Historic England

Our ref: PL00797992
Telephone 01223 582786

12 February 2025

Re: EAST PYE SOLAR ENVIRONMENTAL IMPACT ASSESMENT (EIA) SCOPING REPORT

Figure 7.1.1
Zone of Theoretical Visibility (ZTV)
Combined Viewsheds with View Locations

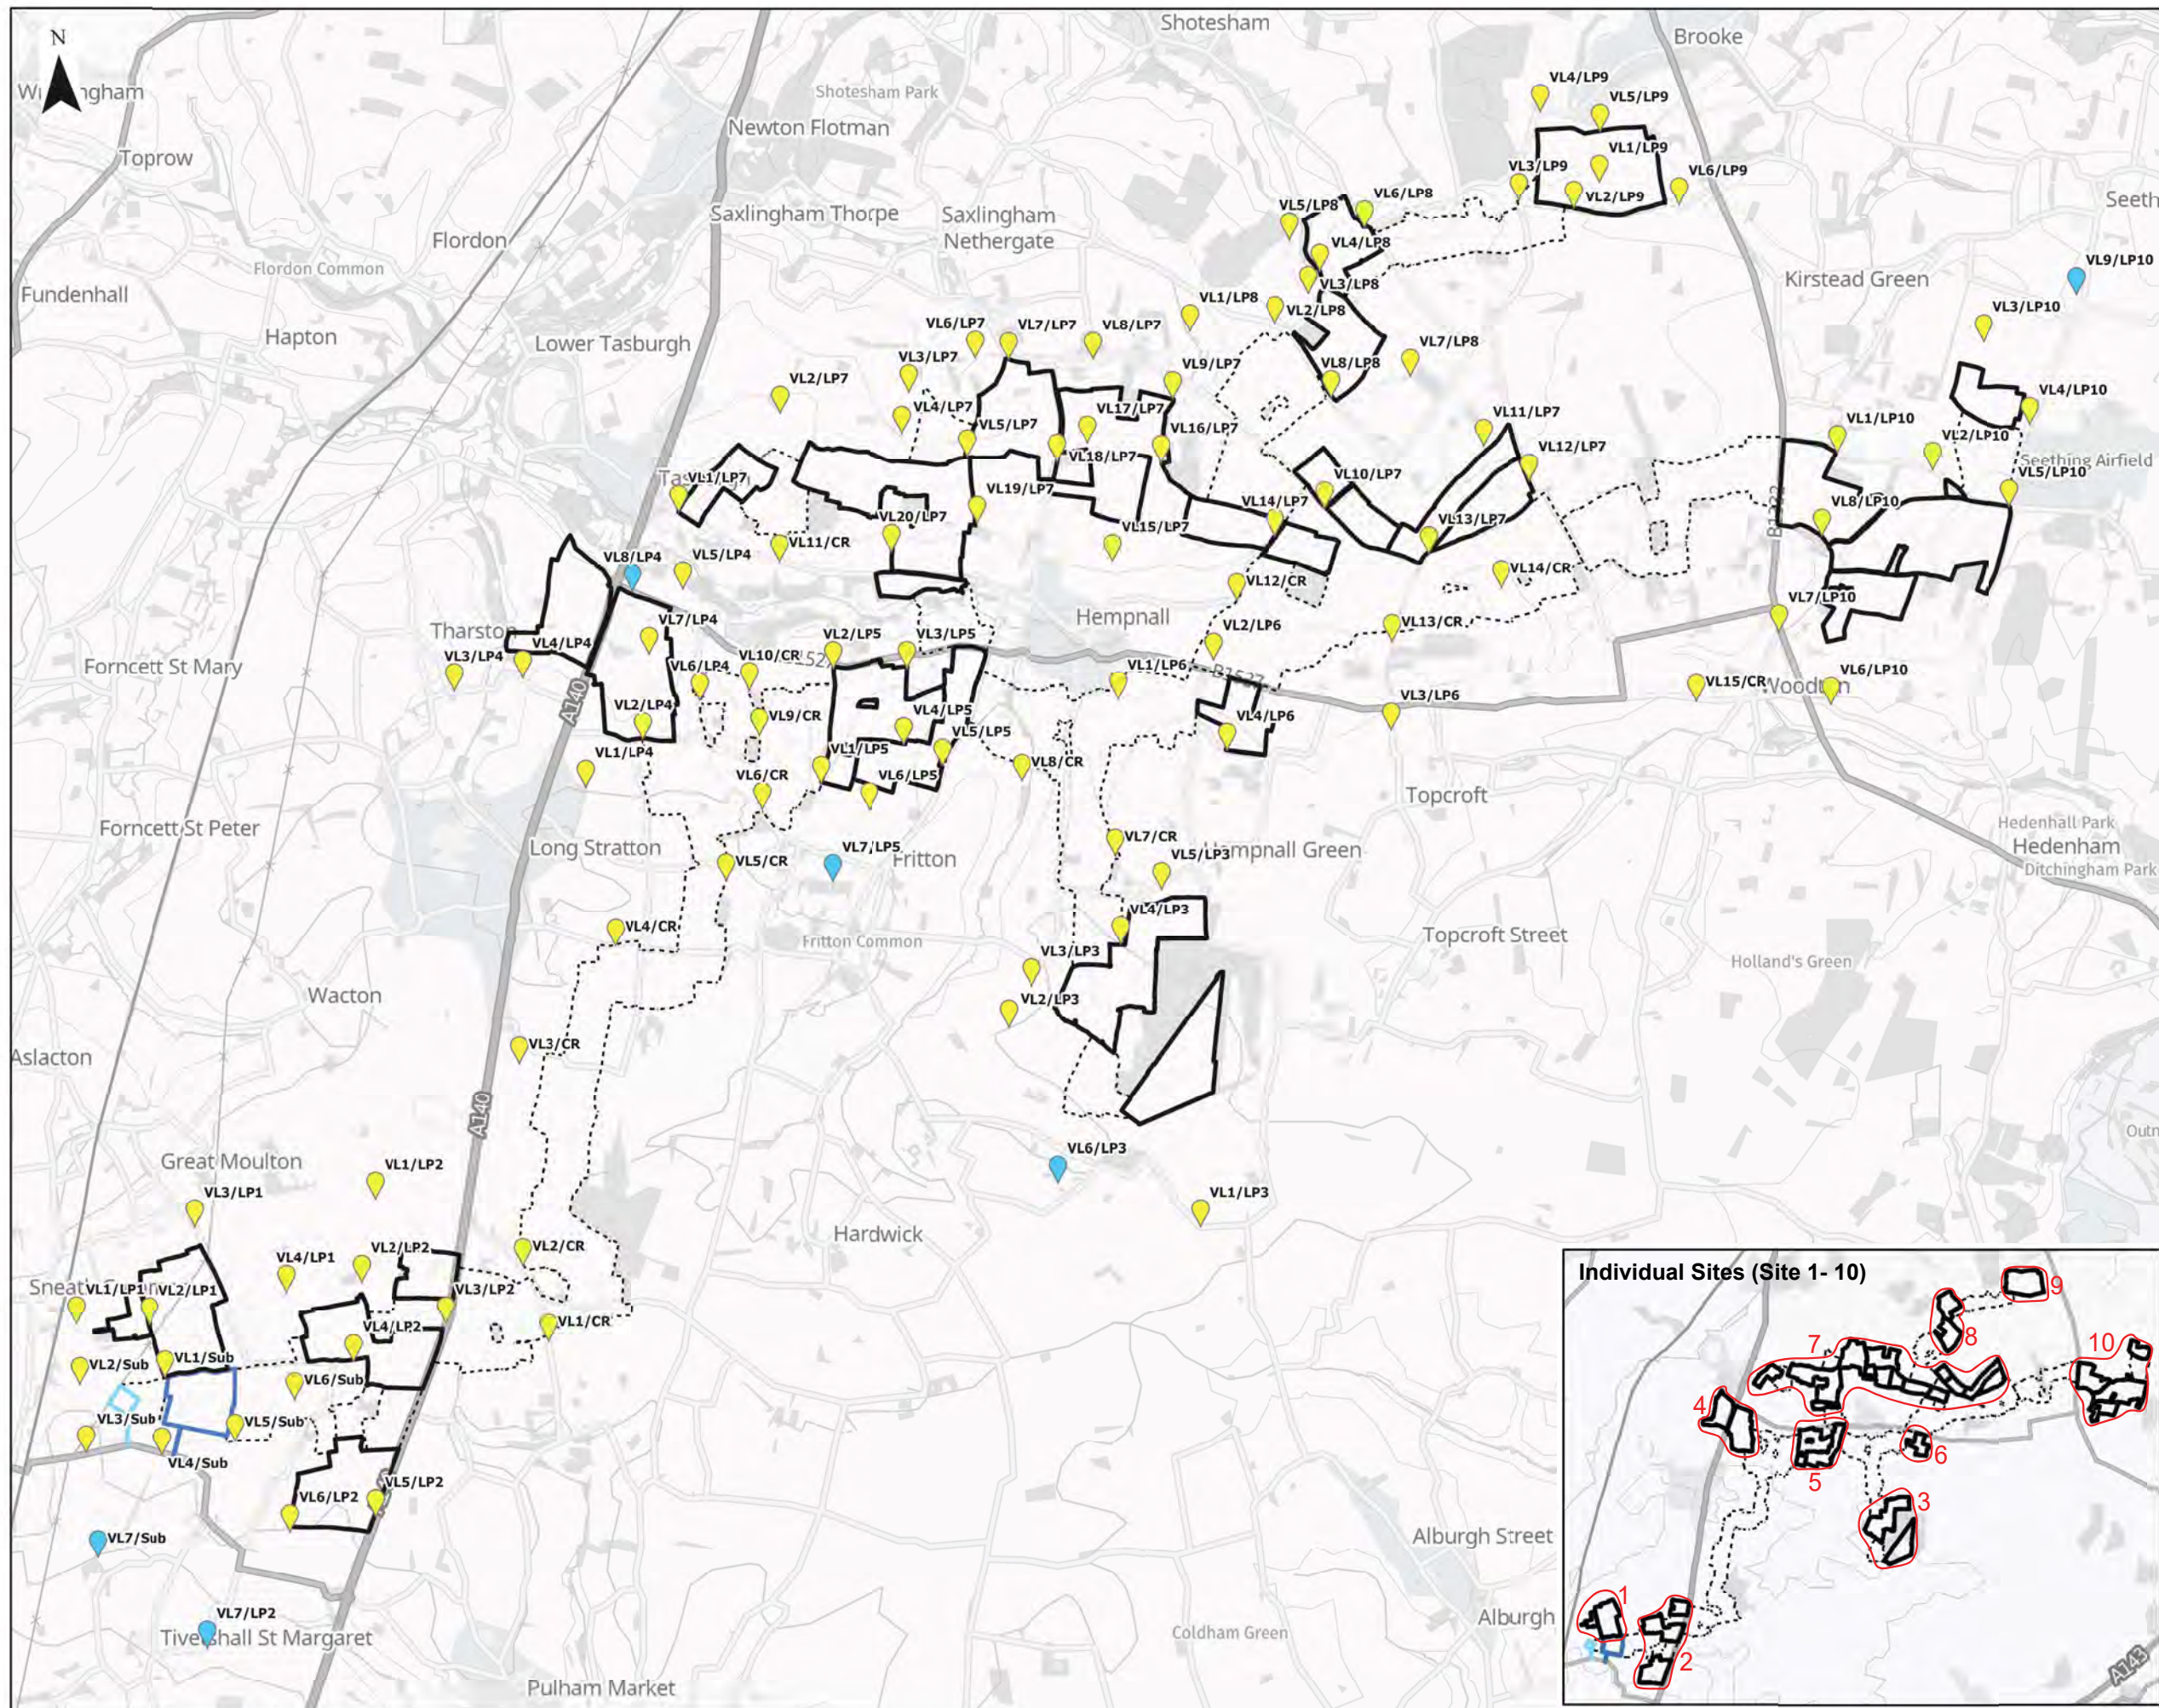
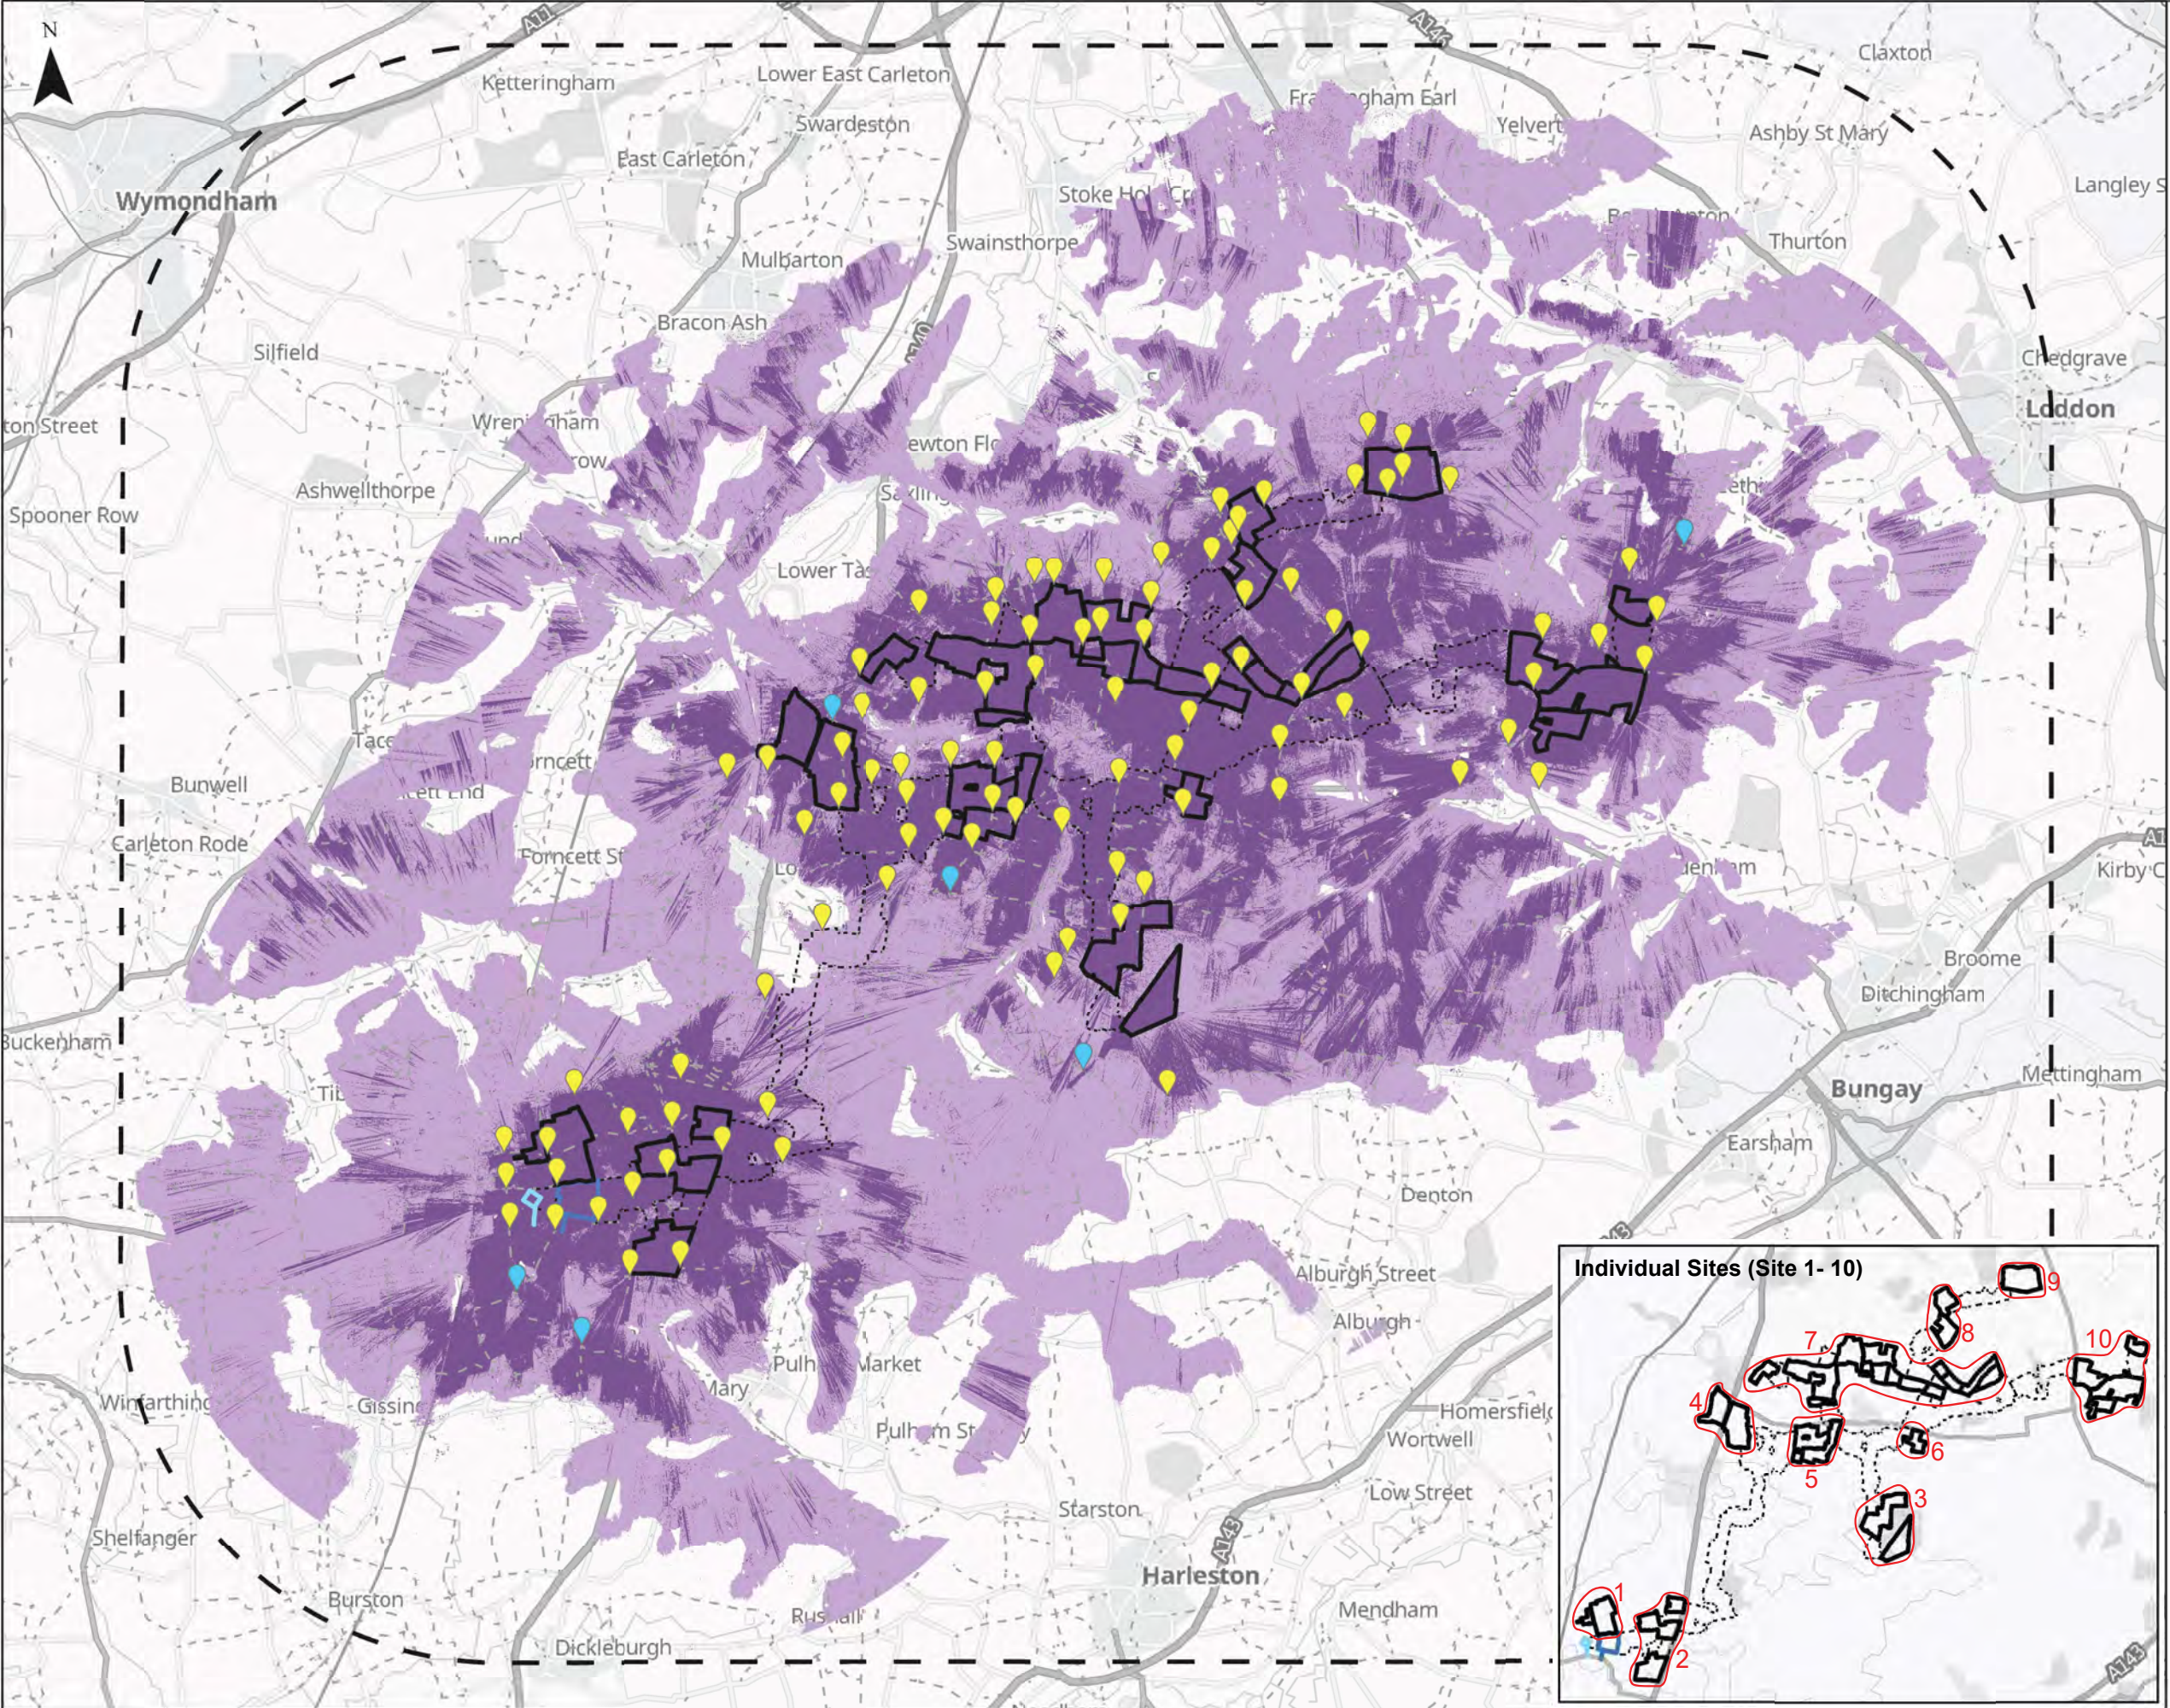
It is important to identify all heritage assets that may be affected on the basis of an appropriately defined study area usually underpinned by a ZTV map (Zone of Theoretical Visibility). This should include heritage assets whose setting may be affected which may be at some distance from the site. It is important that the assessment is designed to ensure that all impacts can be fully understood. Sectional

drawings and techniques such as wireframe and photomontages are a useful part of this.
